Application number: 2023/91327	
What is the application for?:	Erection of detached dwelling
Address of the site or building:	adj, 152, Somerset Road, Almondbury, Huddersfield, HD5 8HY
Postcode:

Type of comment: An objection	
Do you wish your comments to be published on the website anonymously?	Yes
<p>These updated comments should be read in conjunction with those raised against application number 2020/62/91049/W</p> <p>Plan drawing</p> <p>This has been raised before but has still not been addressed. The plan shows the developers land extending up to the council owned garages behind. This is not correct - there is an access way at the back which is not part of the developers property. Granting this application as it is implies a change of use of that land which is incorrect.</p> <p>Effect on trees and the landscape</p> <p>The developer has already felled all the existing trees and shrubs. This was done after the application stating that there were no trees affected was submitted.</p> <p>Design, appearance and layout</p> <p>The plans still show large areas of white rendered walls which are completely out of character with the other houses in the area. The entire development, if it g

PROPOSED SITE PLAN

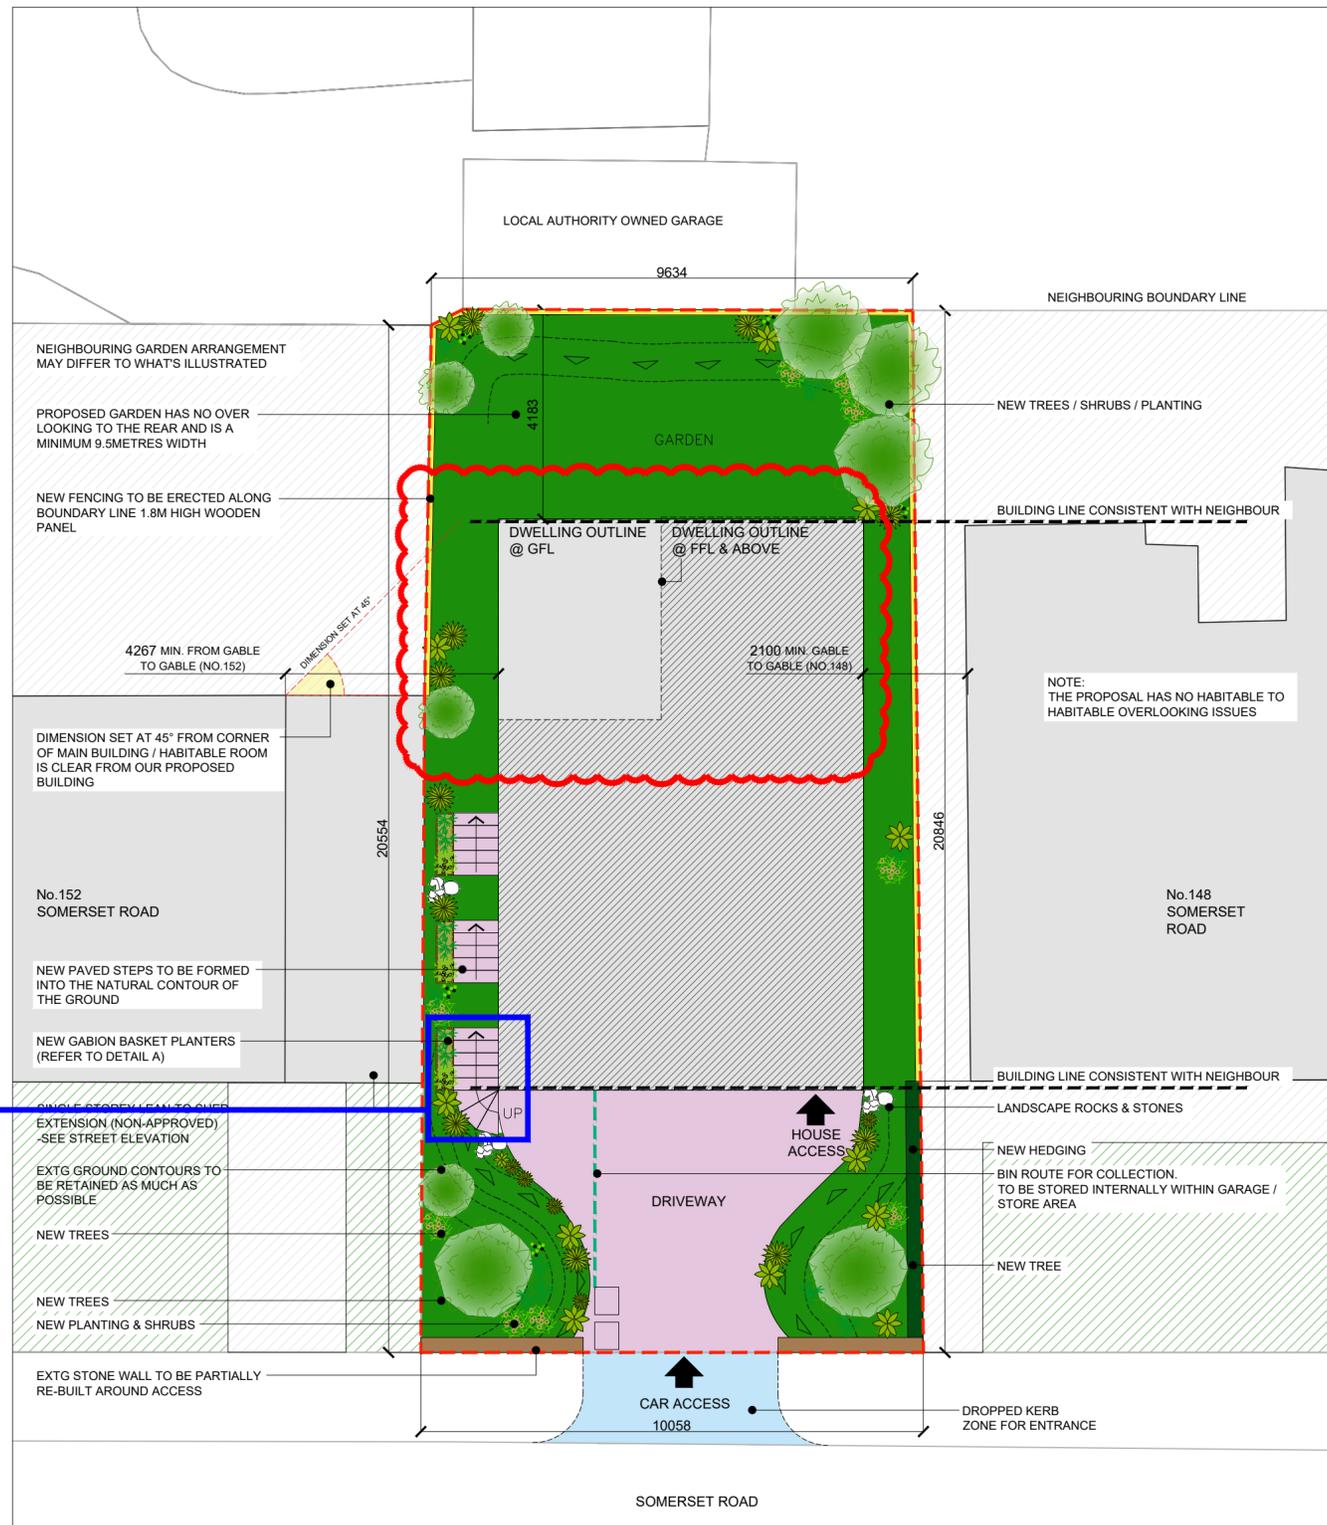
The trees which will be planted in the rear garden will very quickly grow to block most of the sunlight from 148's garden.

DRAWING:
PROPOSED ELEVATIONS

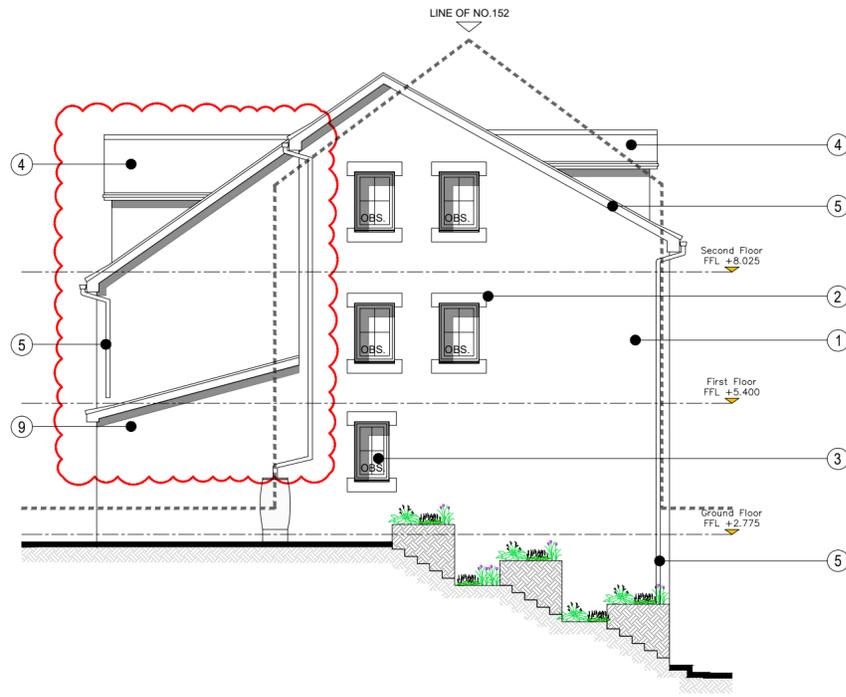
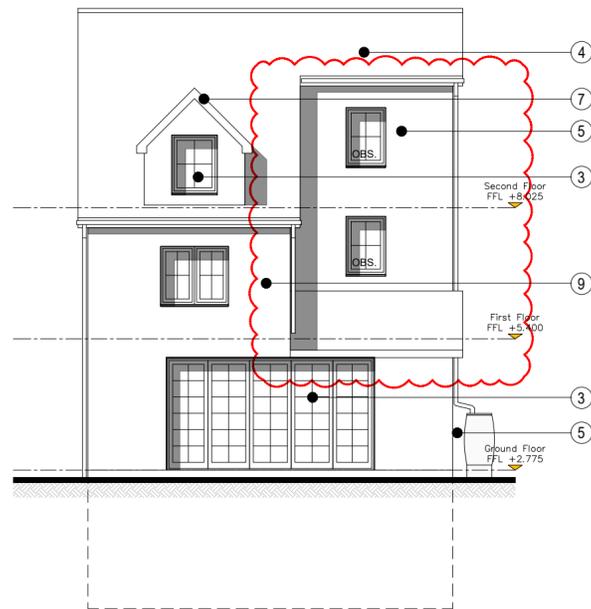
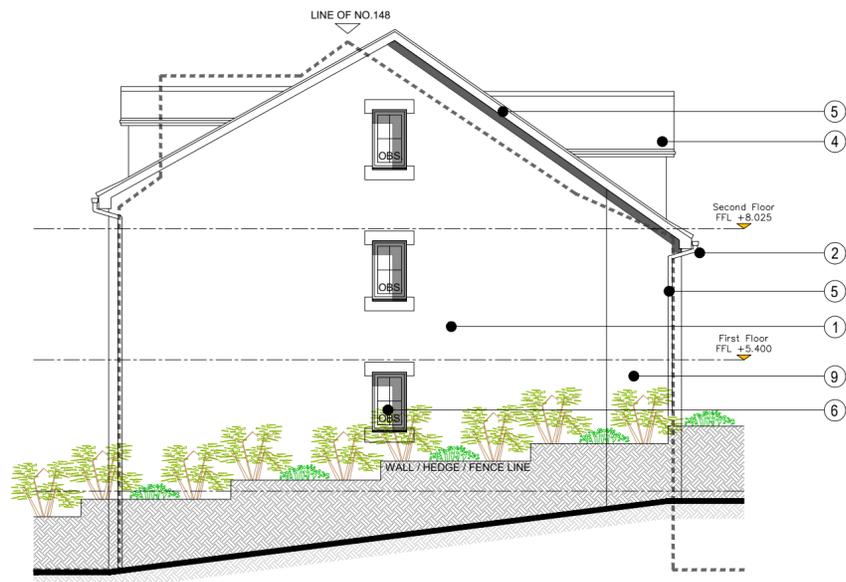
I note that the plans indicate obscure glass on all the side elevations - I assume this will be enforced otherwise the new property will have direct line of sight into neighbouring bedrooms.

DRAWING:
PROPOSED GA PLANS

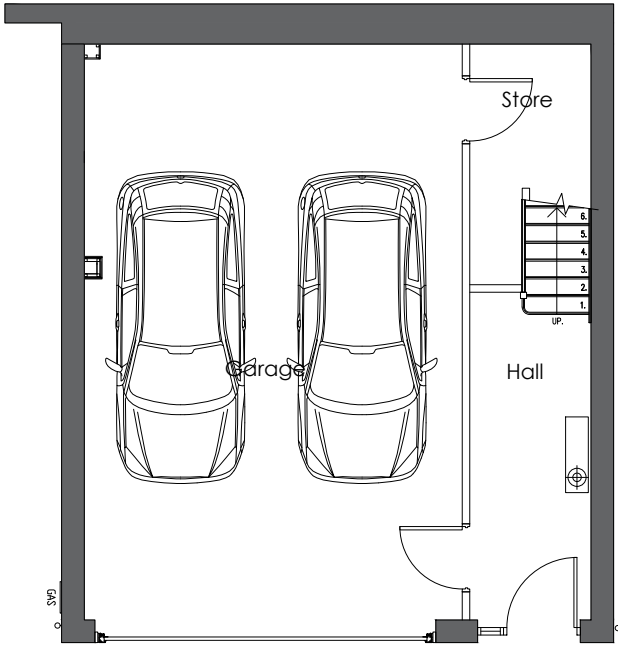
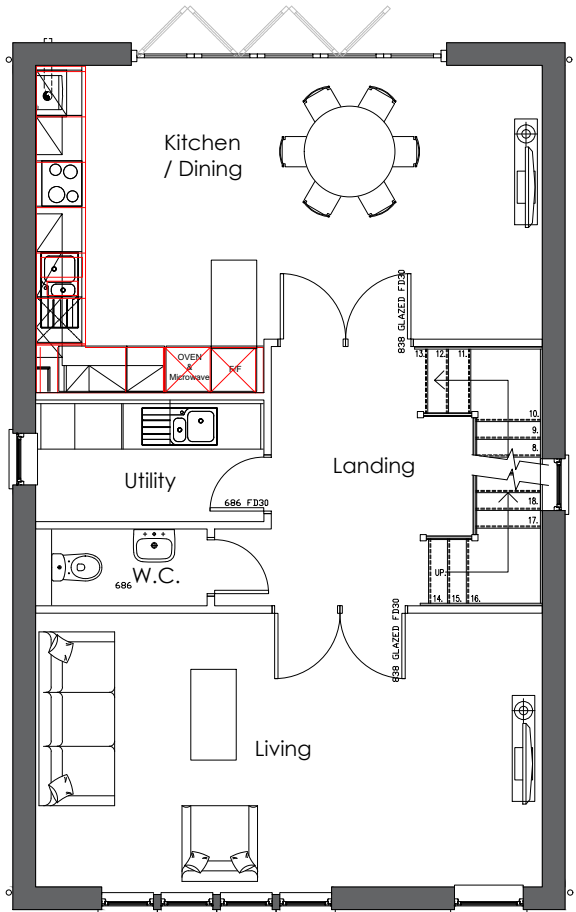
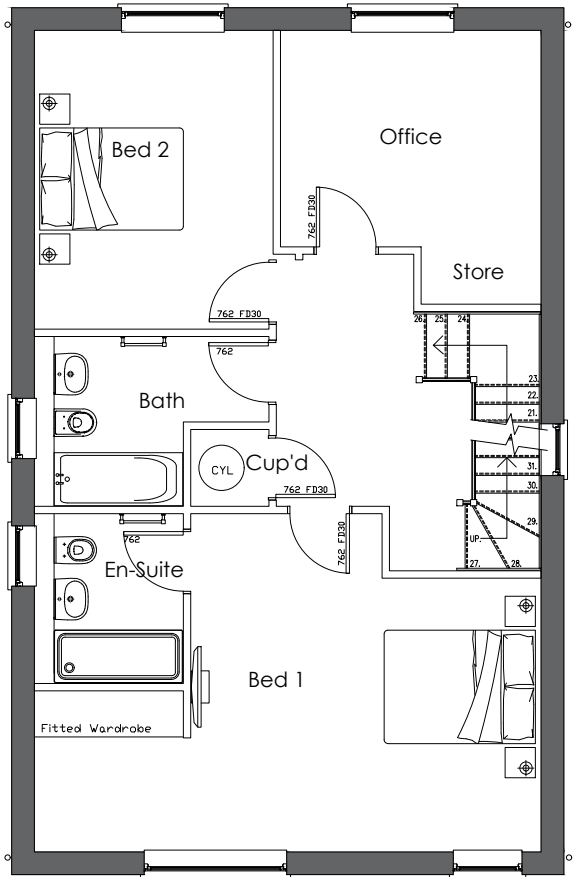
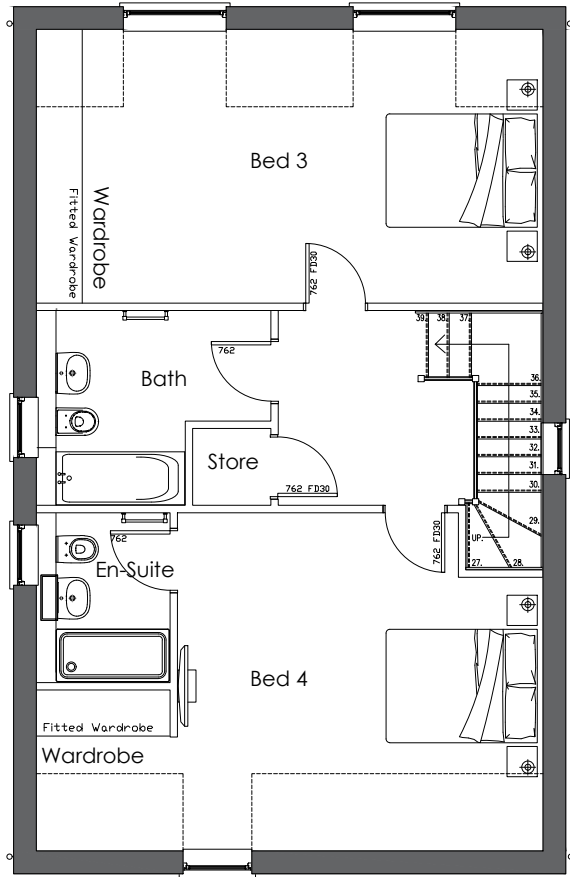
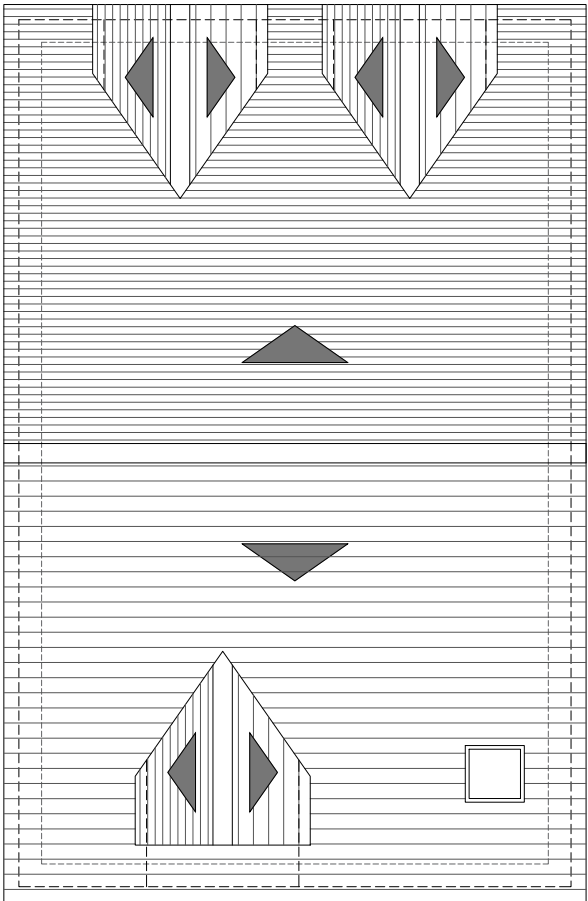
Storage of the wheelie bins is shown as being inside the garage however this will simply reduce the access to the garage preventing the keeping of two vehicles within and as has been pointed out previously, the driveway is only big enough for one vehicle.
